L & L STRUCTURAL
ENGINEERING SERVICES, INC.
Six Q Street
South Portland, ME 04106
Telephone: 207 767-4830

July 12, 2016

Subject: Building located at 1 Saint Lawrence Street, Portland, Maine
Three Story Exterior Deck/Porch Assessment

**S2**

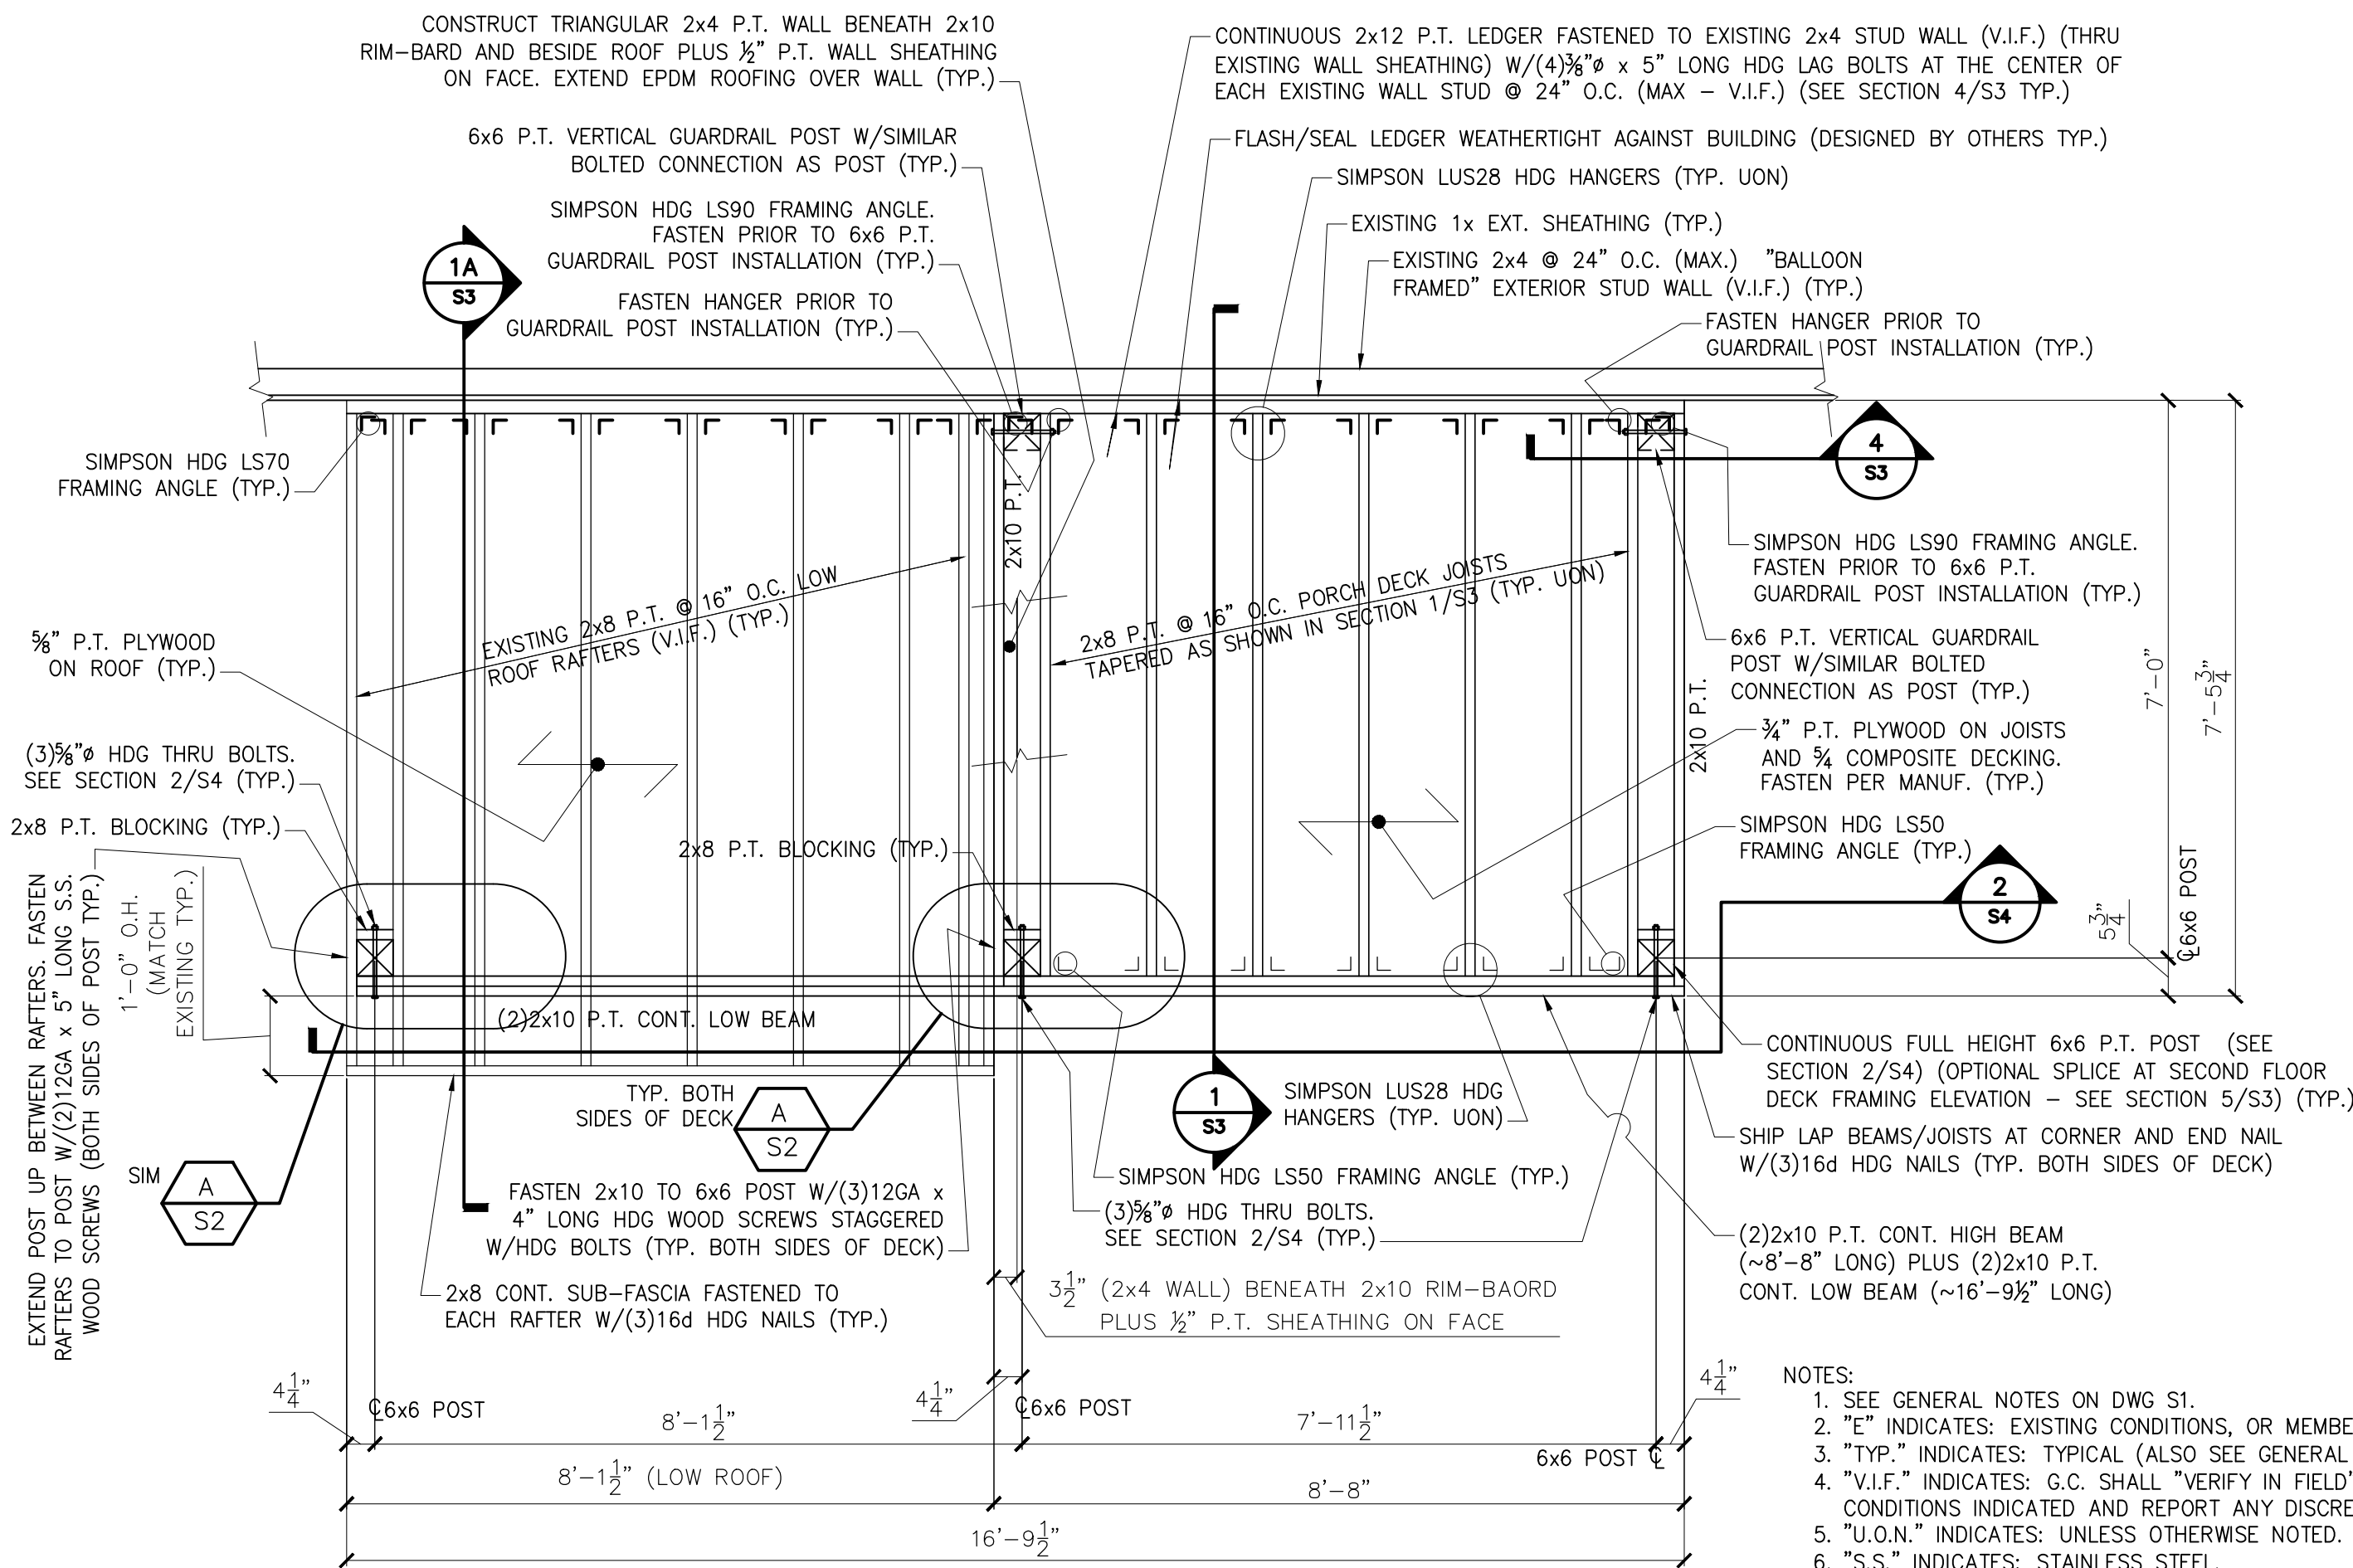
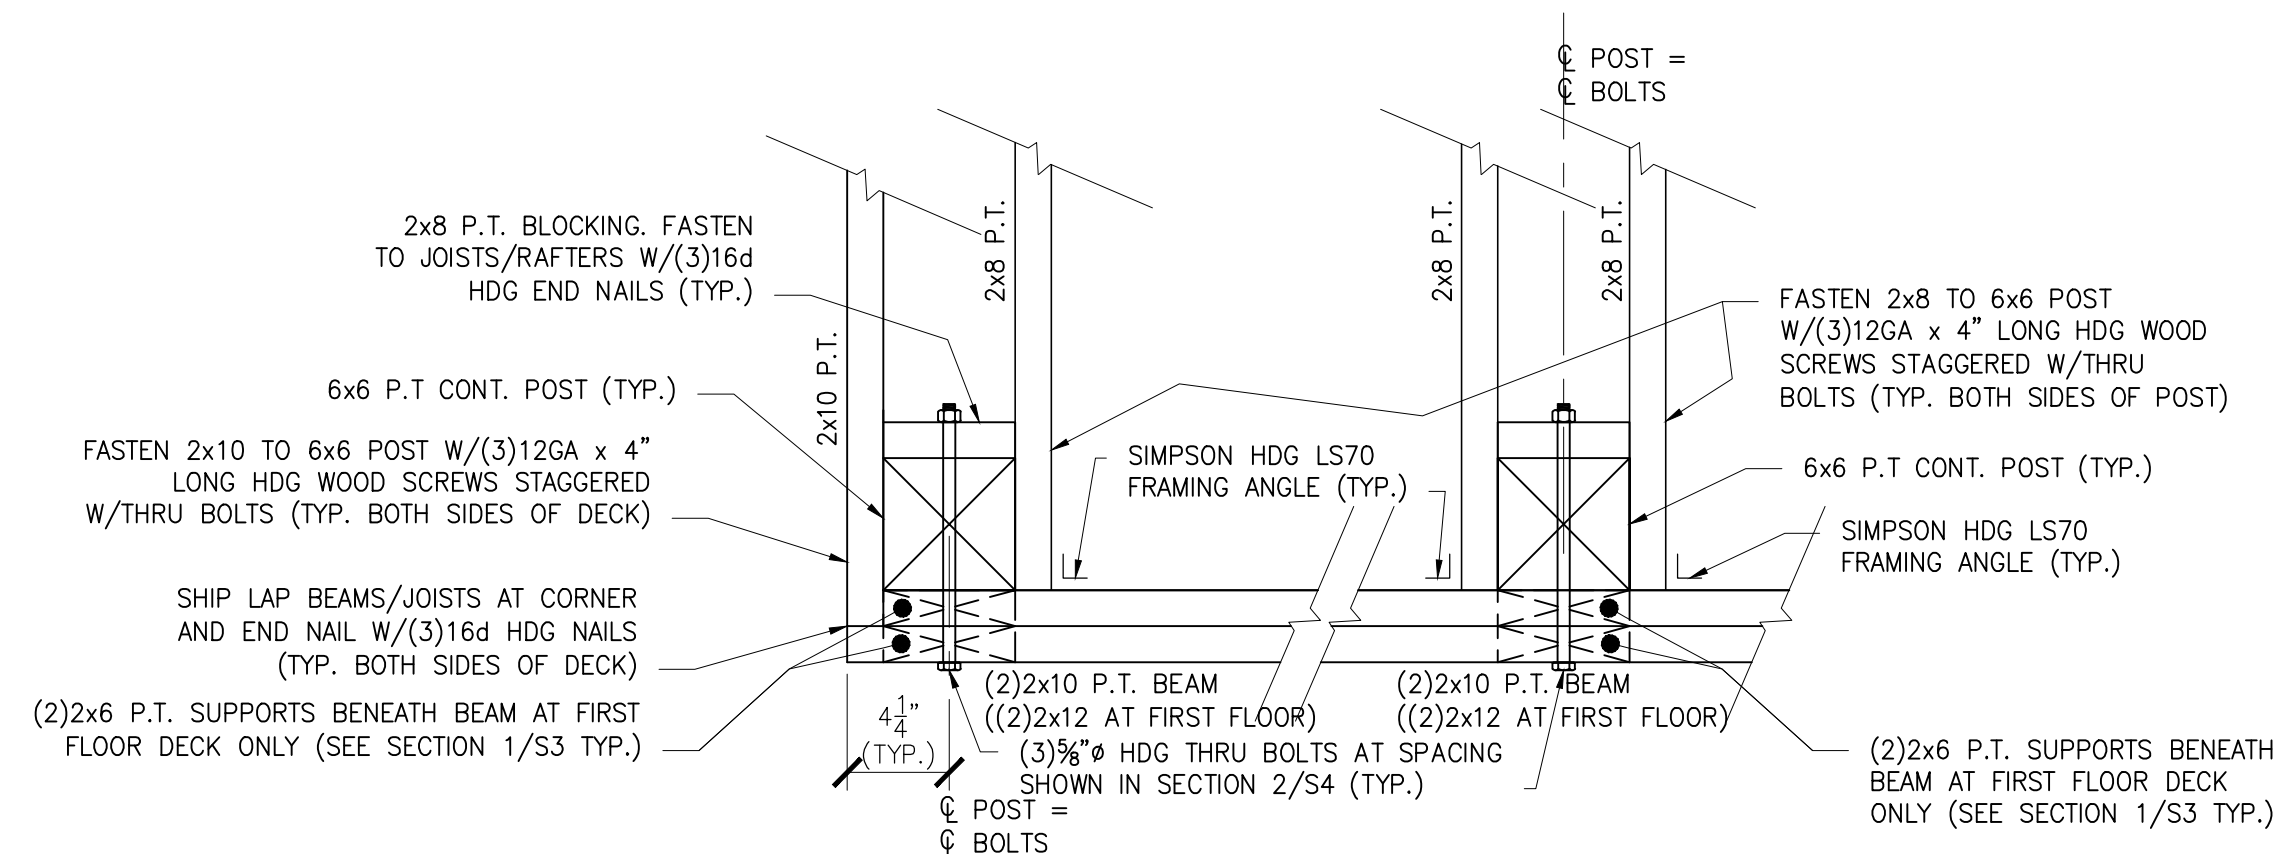
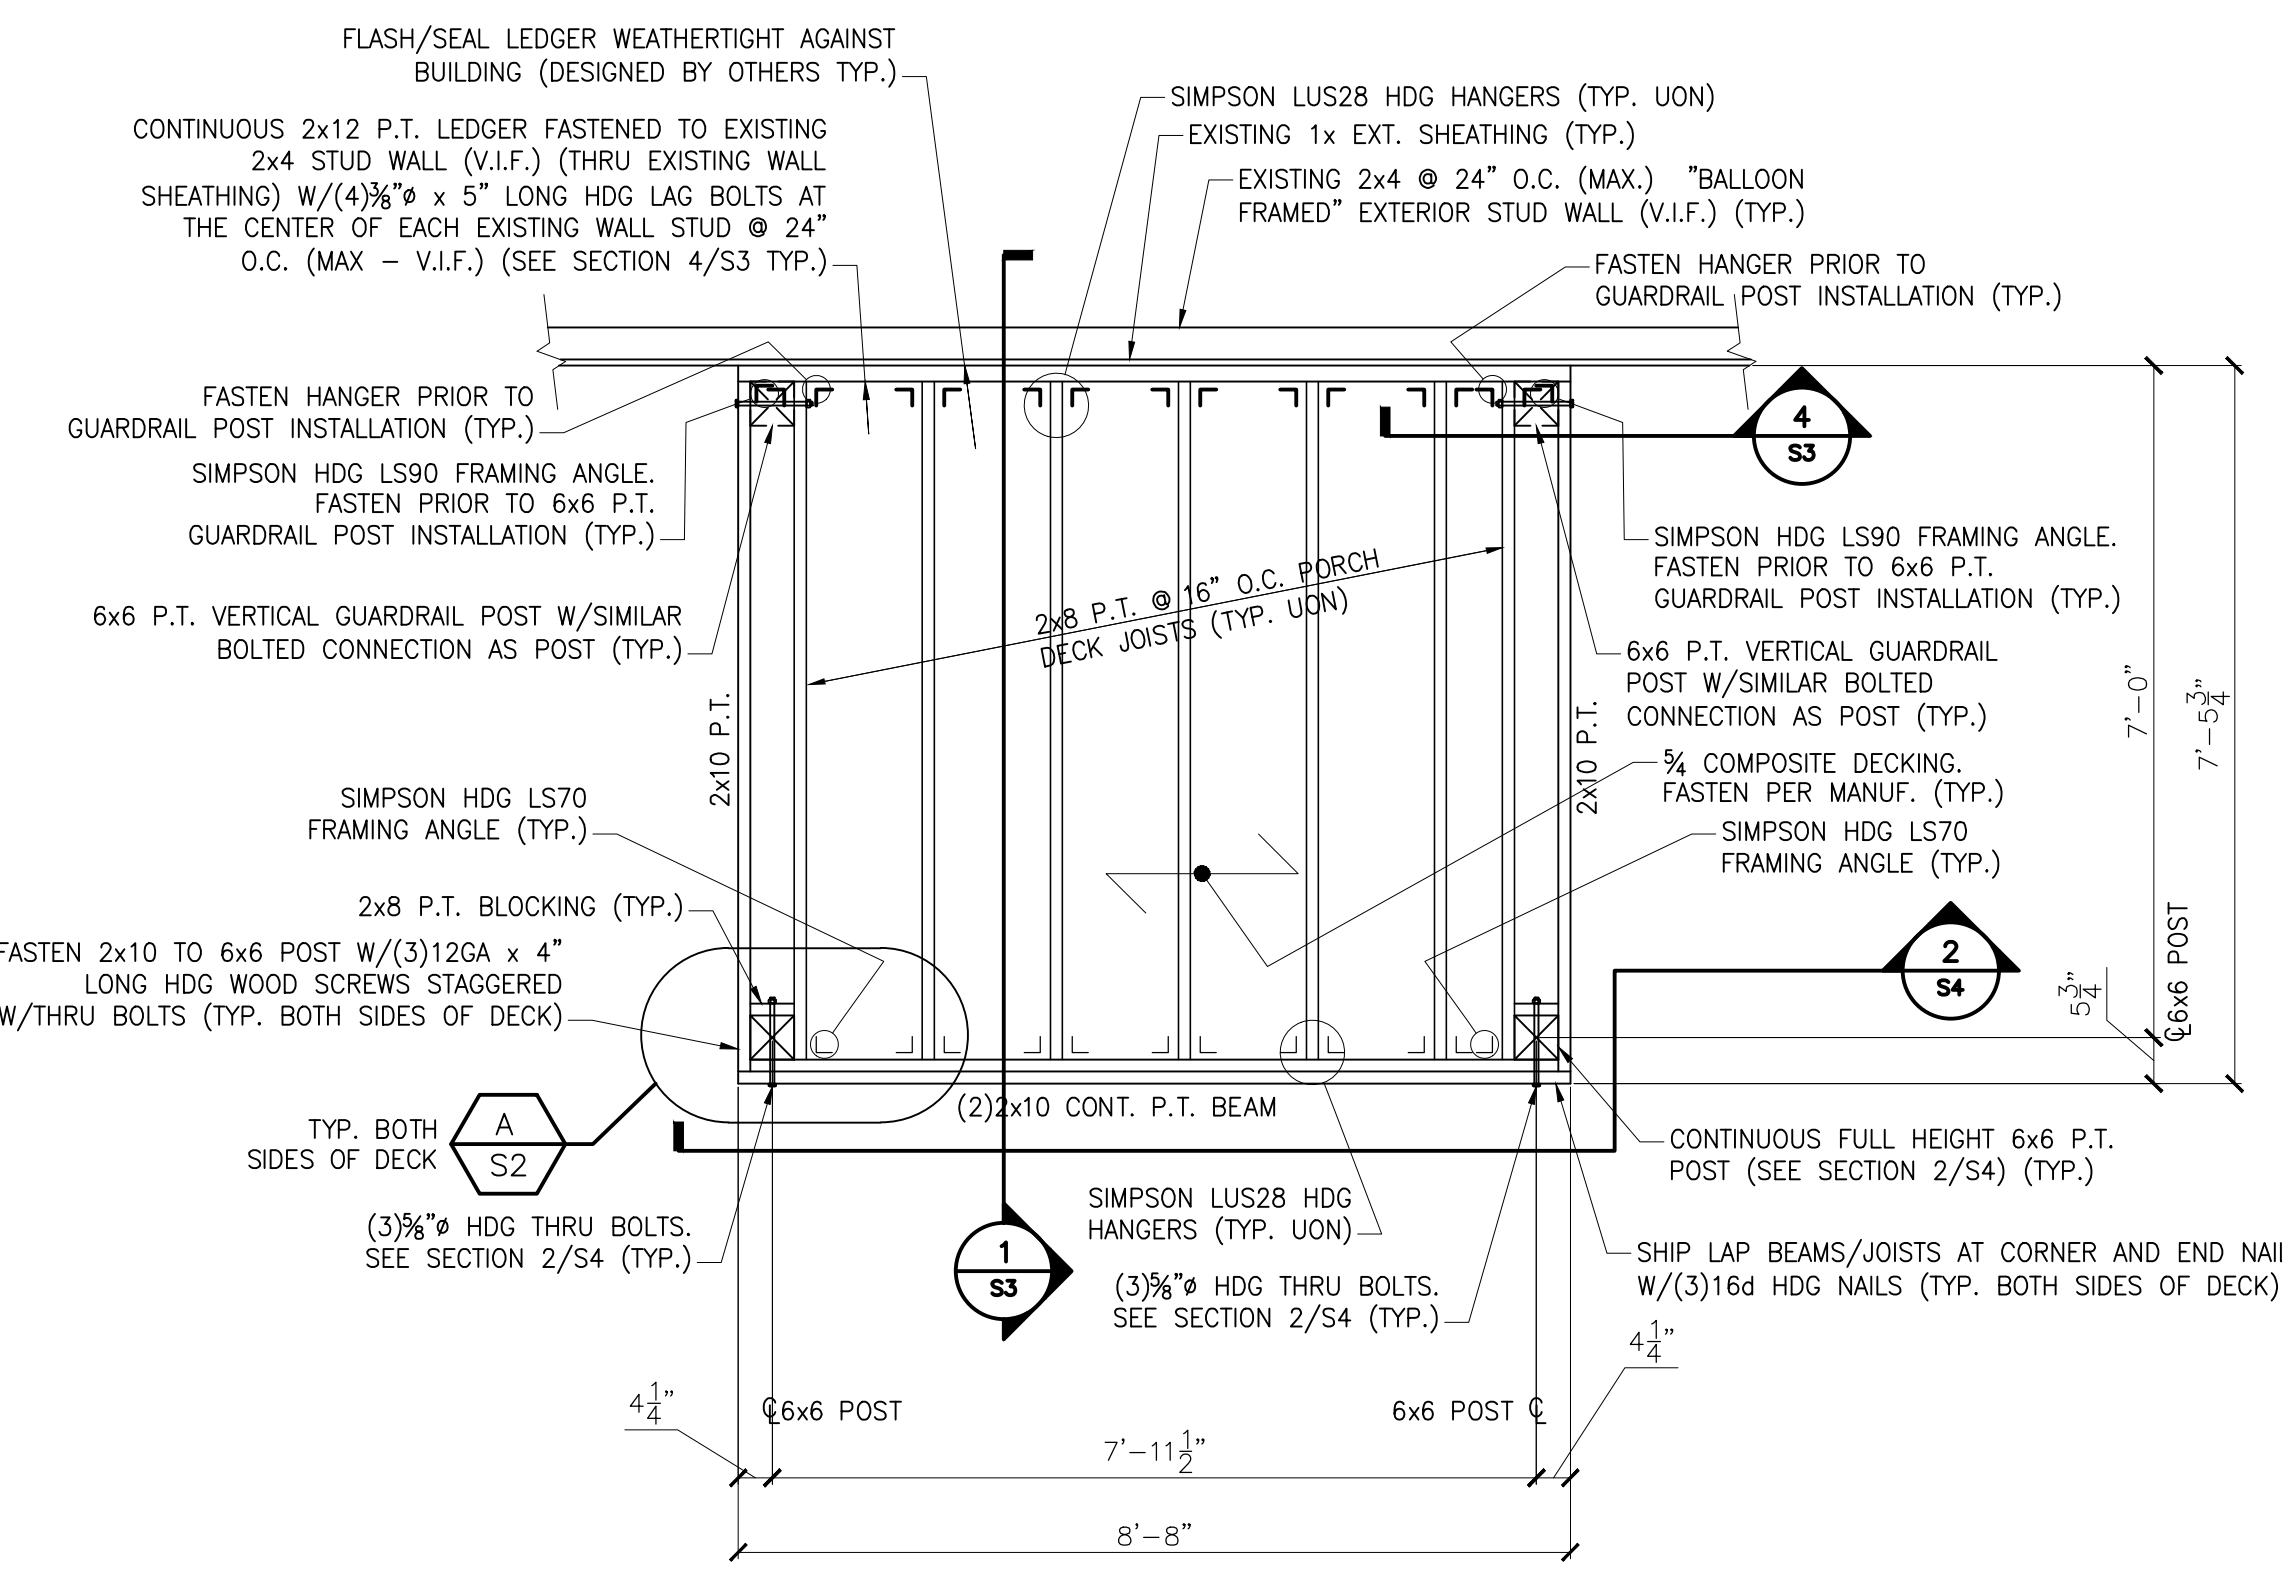
1. The existing timber post at the right side of the first floor deck and the beam on top are deteriorated and require replacement. The replacement of the beam will require temporary support of the existing structure above to remove and replace the compromised timber post and beam. In addition, the post is continuous through the first floor deck and therefore replacement will require temporary support and partial disassembly of the first floor deck as well. The rainwater that currently penetrates the third and second floor decks has been directed with a tarp to a gutter attached to the interior face of the existing second floor beam in an attempt to keep water off of the first floor deck. The system does not appear to be functioning properly and water/moisture has become trapped within finish boards against the interior face of the existing timber beam and top of the post causing the deterioration to occur. We recommend abandoning the current rainwater diverter system until something more permanent and properly directed is able to be installed.

2. The existing beam on the right side of the center post is not adequately supported on the existing center post. The right beam is only supported approximately 1/2" on the existing post. In addition, the existing beam is experiencing some deterioration at the support on the post as well. Furthermore, the post above (which supports the third floor deck) is offset approximately 6" (center to center) from the existing post at the first floor below which exacerbates the lack of bearing issue as well as overstresses the existing beam beneath the second floor deck. This condition is unsafe and shall be remedied immediately.

3. The second floor deck is not adequately braced to resist lateral (wind and/or seismic) loads imposed on the structure. The existing shed roof system offers a timber diaphragm at that level which is adequate to resist the imposed lateral loads. However, the timber roof diaphragm and /or roof structure is inadequately fastened to the existing main building structure and there is probably inadequate structure within the main building (to be determined) to resist the lateral shear and tension/compression loads resulting from the diaphragm. The second floor deck requires adequate bracing to be installed.

4. The third floor deck is grossly inadequately braced to resist lateral (wind and/or seismic) loads imposed on the structure. The third floor deck structure (diaphragm) is inadequately fastened to the existing main building structure and there is probably inadequate structure within the main building (to be determined) to resist the lateral shear and tension/compression loads resulting from the diaphragm. We imposed a relatively small force (force of a man pushing) on the side of the existing post beneath the third floor deck and the deck moved approximately 1" laterally. In addition, the existing 4x4 timber posts beneath the existing third floor deck do not have sufficient strength to be used along with the existing third floor deck beam to create a braced frame by adding corner braces. Hence, the existing post would require reinforcement if used as part of a braced frame to resist lateral loads. The third floor deck requires adequate bracing to be installed and reinforcement or replacement of the existing posts.

5. The existing roof rafters and deck joists are not adequately supported from the existing ledger with metal joist hangers which will need to be installed.

6. The existing ledger at the second floor deck (and adjacent shed roof) and the ledger at the third floor deck are not adequately fastened to the structure in the main building. Additional fasteners are required into to the assumed balloon framed stud wall system (to be confirmed) to adequately support the code stipulated loads imposed on the decks.

7. The existing ledger at the first floor deck is not adequately fastened to the structure in the main building. Additional fasteners are required into to the existing brick wall foundation system to adequately support the code stipulated loads imposed on the decks.

8. The existing guardrail system does not appear to have adequate strength nor connection to the deck structure to resist the code stipulated loads. The existing guardrail system would need to be reinforced, supplemented or replaced with a properly designed and installed guardrail system.

The structural deficiencies that we discovered, especially items #2 and #4, are a safety hazard and the decks are in imminent danger of collapse. We recommend abandoning the use of the decks until a permanent properly designed and installed reinforcement is able to be implemented or the decks are able to be replaced with a properly designed and constructed deck/porch structure.

2. (cont.) We instructed the contractor to install a 2-2x6 post fastened to the existing 4x4 post to temporarily support the existing beam until the unsafe condition is able to be permanently remedied and to discontinue the use of the exterior decks. If an additional post is to be installed adjacent to the existing post to support the existing beam, an additional foundation system will be required to support the new post and the existing first floor structure will need to be modified and re-supported to allow the new post to be installed.
